Stonestreet Green Solar

Responses to Deadline 2 Submissions

PINS Ref: EN010135
Doc Ref. 8.10
Version 1
Deadline 3
January 2025

Drawing Number: **011998.00001.711** Rev: **01**

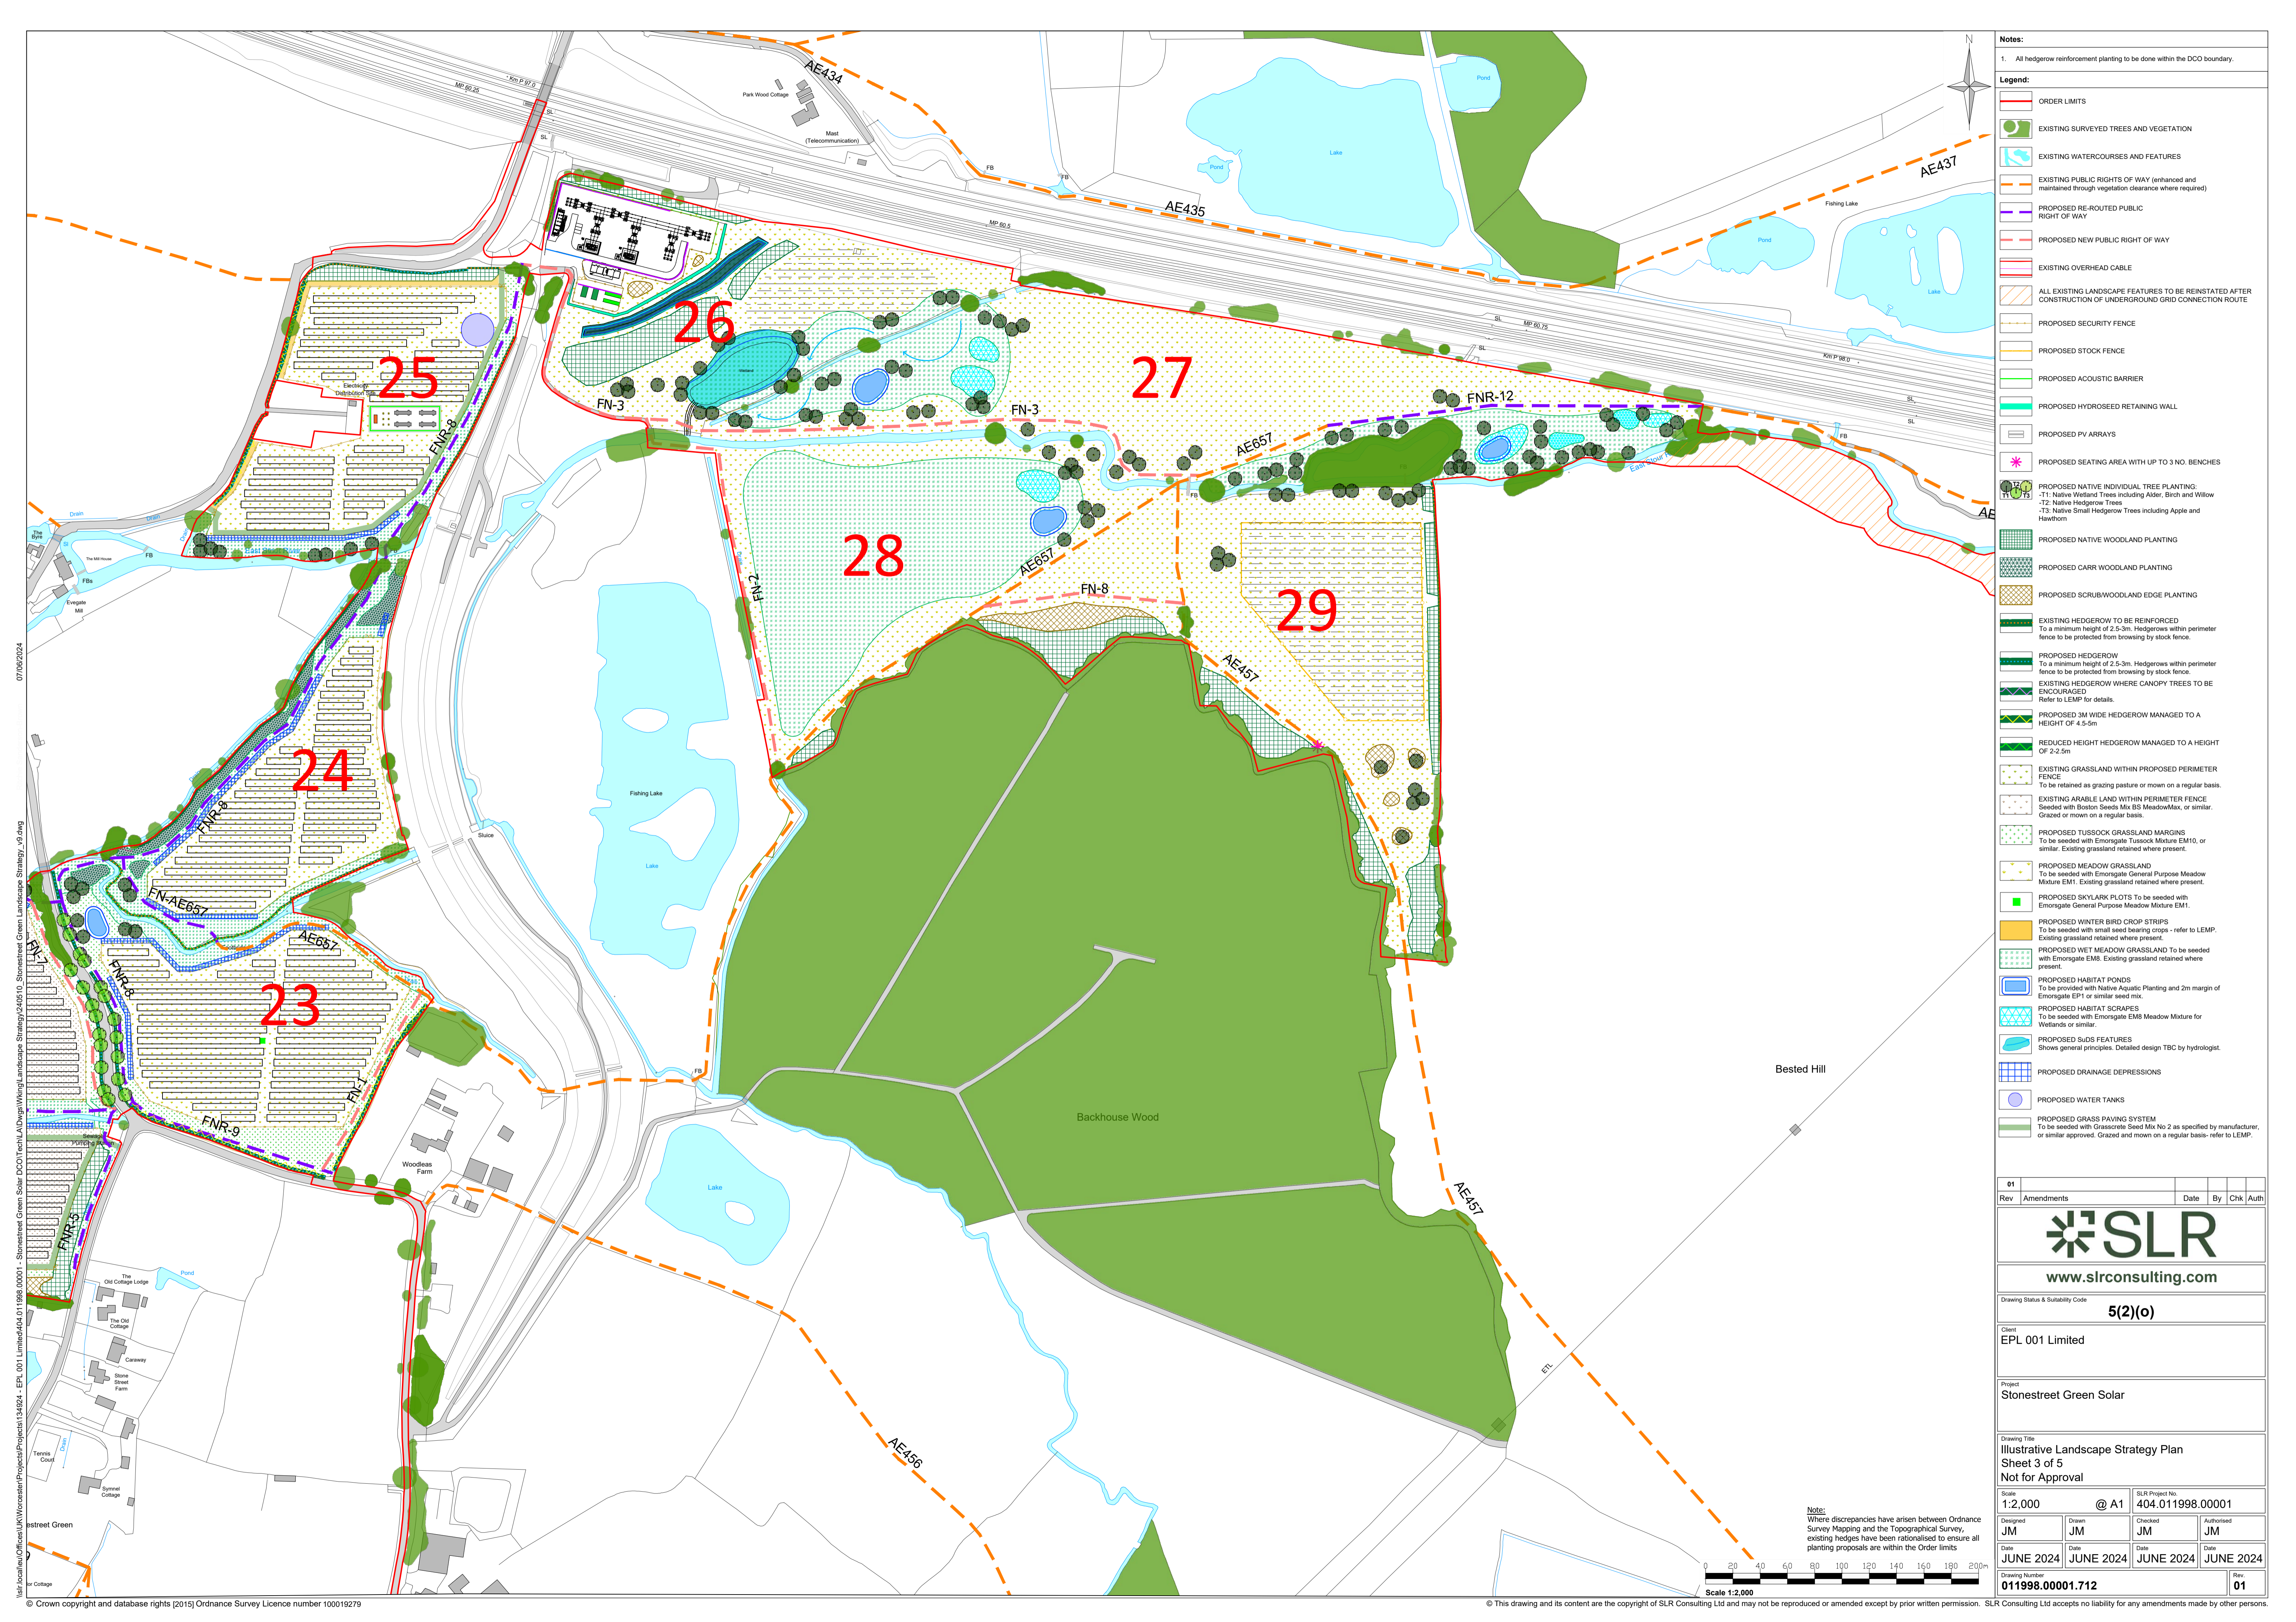
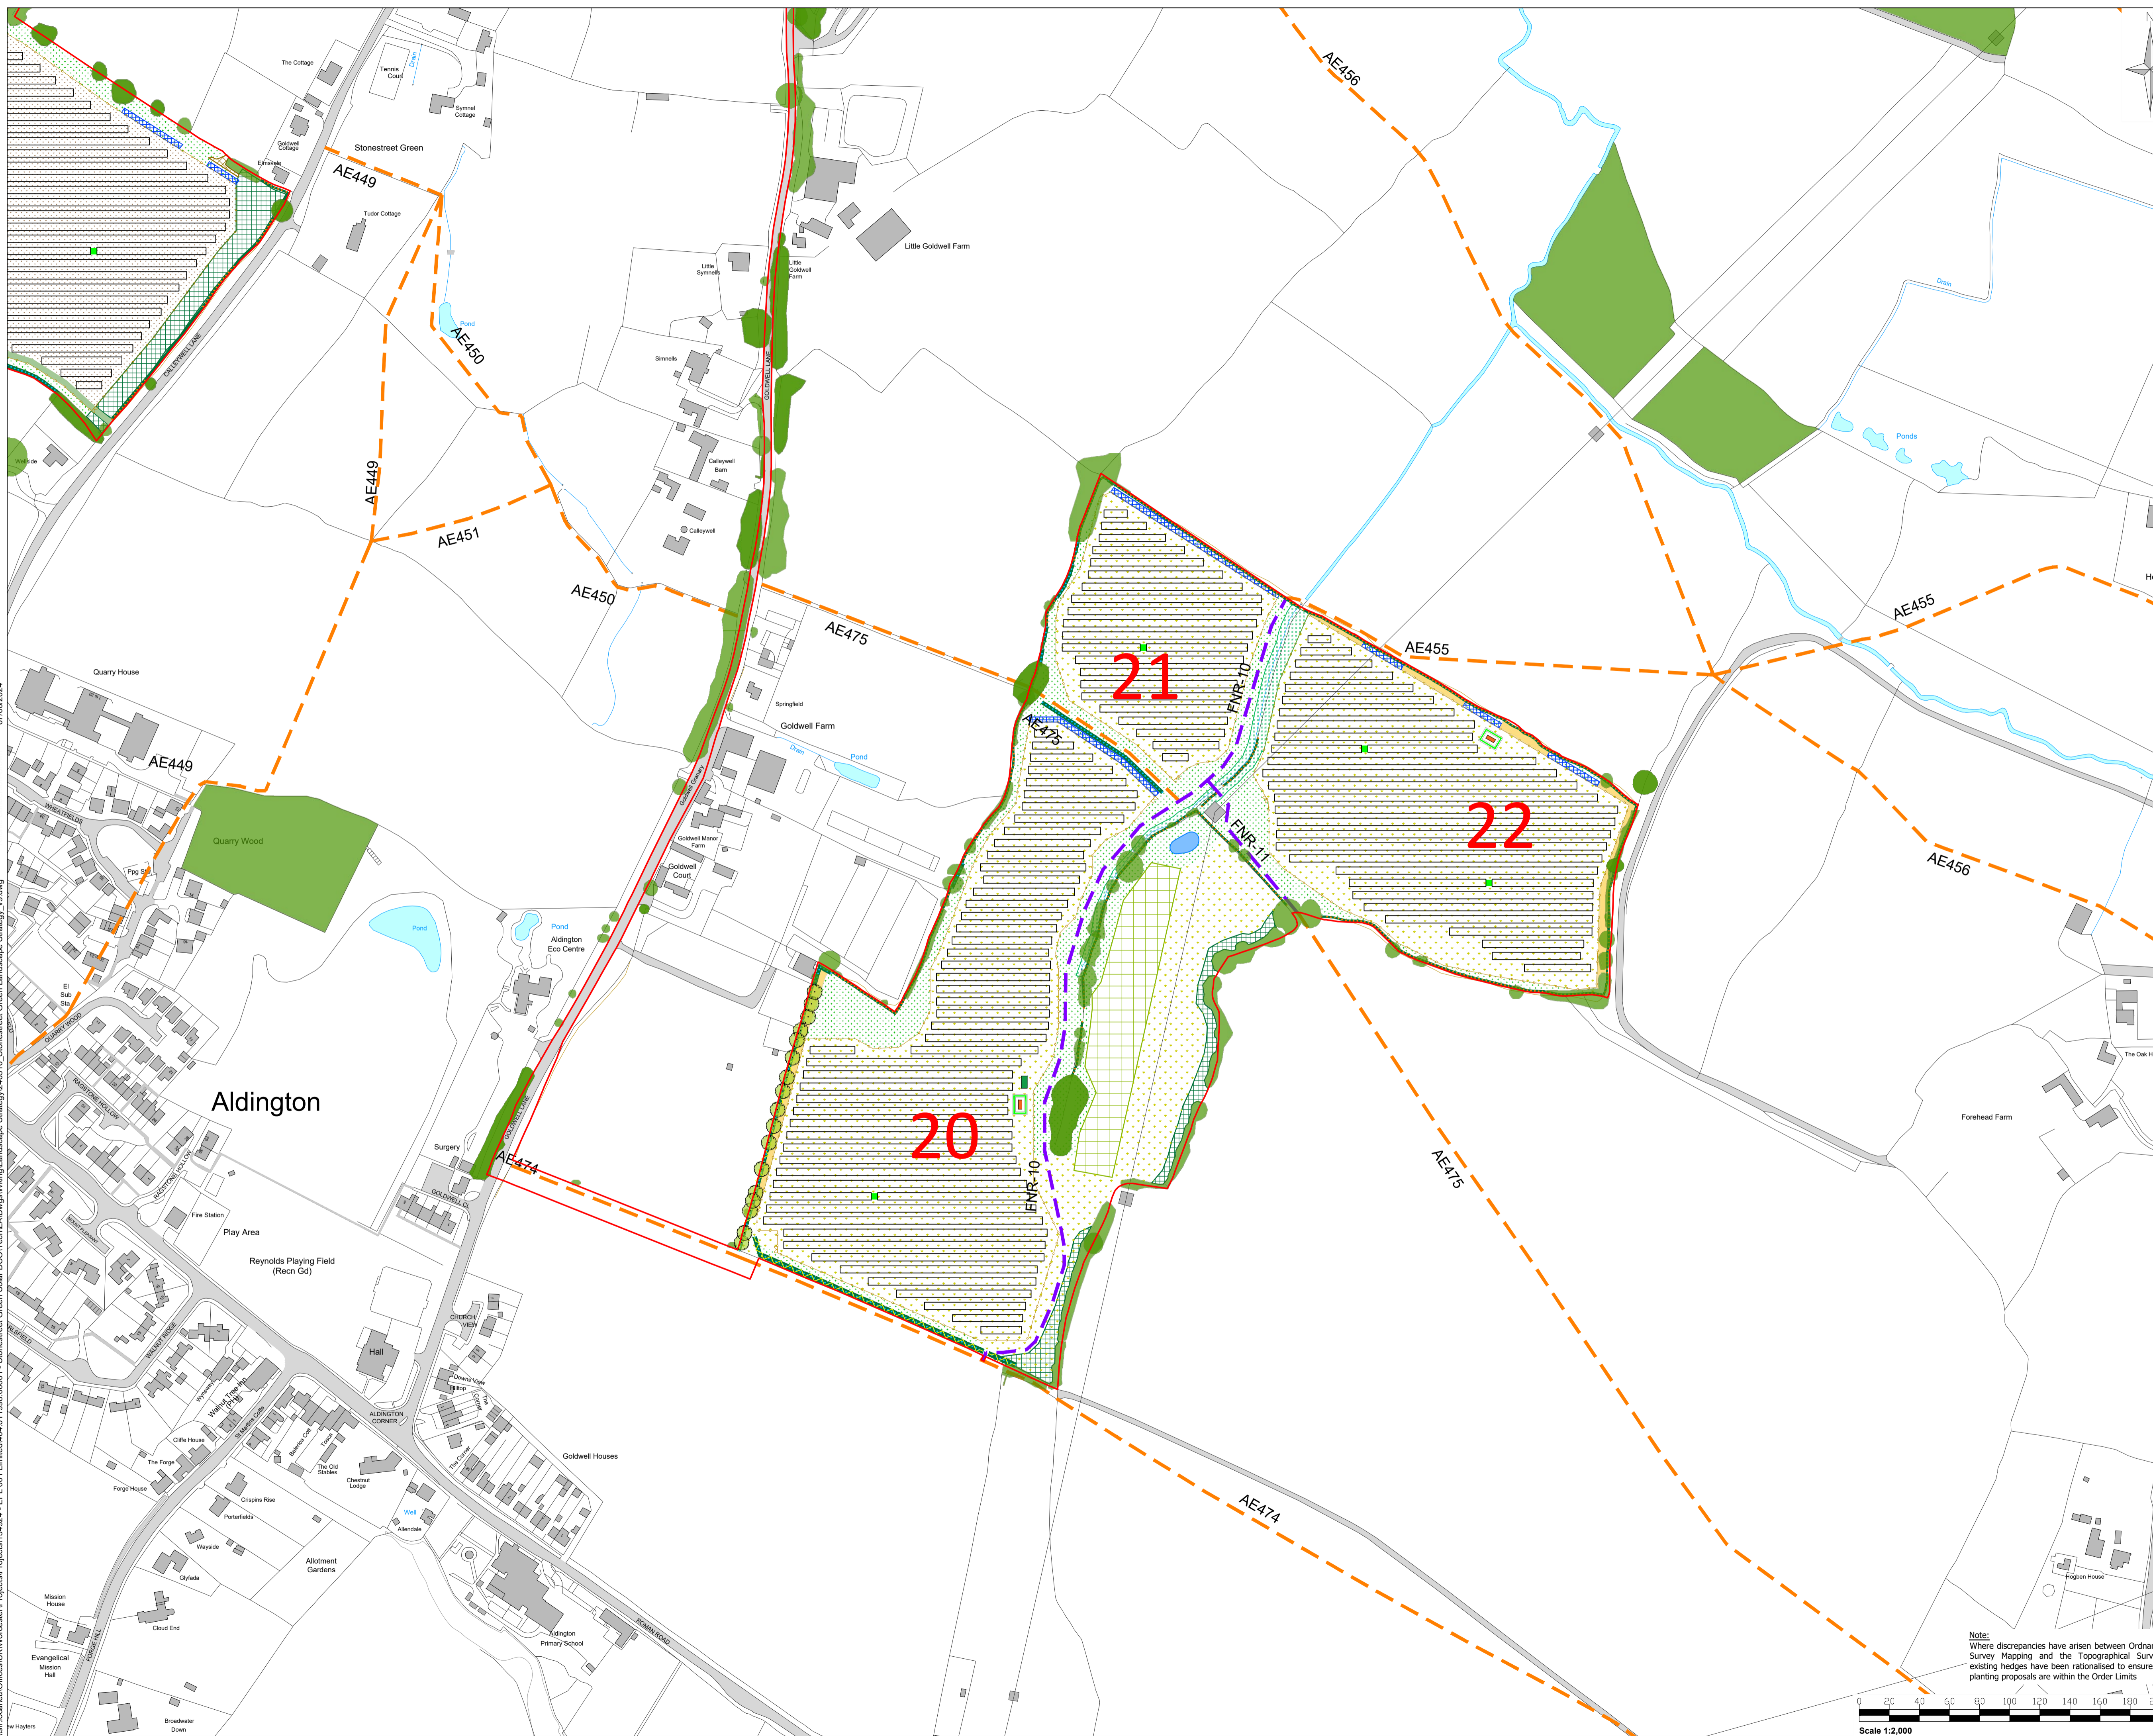
destined to be Tussock Grassland. This may suit land like this which routinely floods each winter but is hardly suitable as replacement Skylark habitat particularly when this species favours short grassland or arable fields which are not close to woodland (because of predation risk). Note fields 27 and 29 are relatively small (not optimal for Skylark), adjacent to established hedges, sporadic woodland by the river and Backhouse Wood. This leaves the so-called “Skylark Plots” to achieve compensation for lost nesting habitat which are the tiny green squares on the plan below which is an extract from the Applicant’s illustrative plan Doc. Ref 2.7 (note, not for approval).

Possibly the Applicant’s ecologists consider that the recommended 2 No.16 m² Skylark plots/HA recommended for increasing Skylark numbers in autumn sown cereals (as shown below) is equally applicable when located in the middle of the metal and glass of a solar array. If so, where is the evidence that this has worked in the same way to increase Skylark nesting, and what happens if this mitigation proves to be inadequate? Will some of the panels be removed?

Please refer to Table 3-2: Response to Aldington and Mersham Support Group, ‘Biodiversity’, **Responses to Relevant Representations (Doc Ref. 8.2)** [\[REP1-061\]](#).
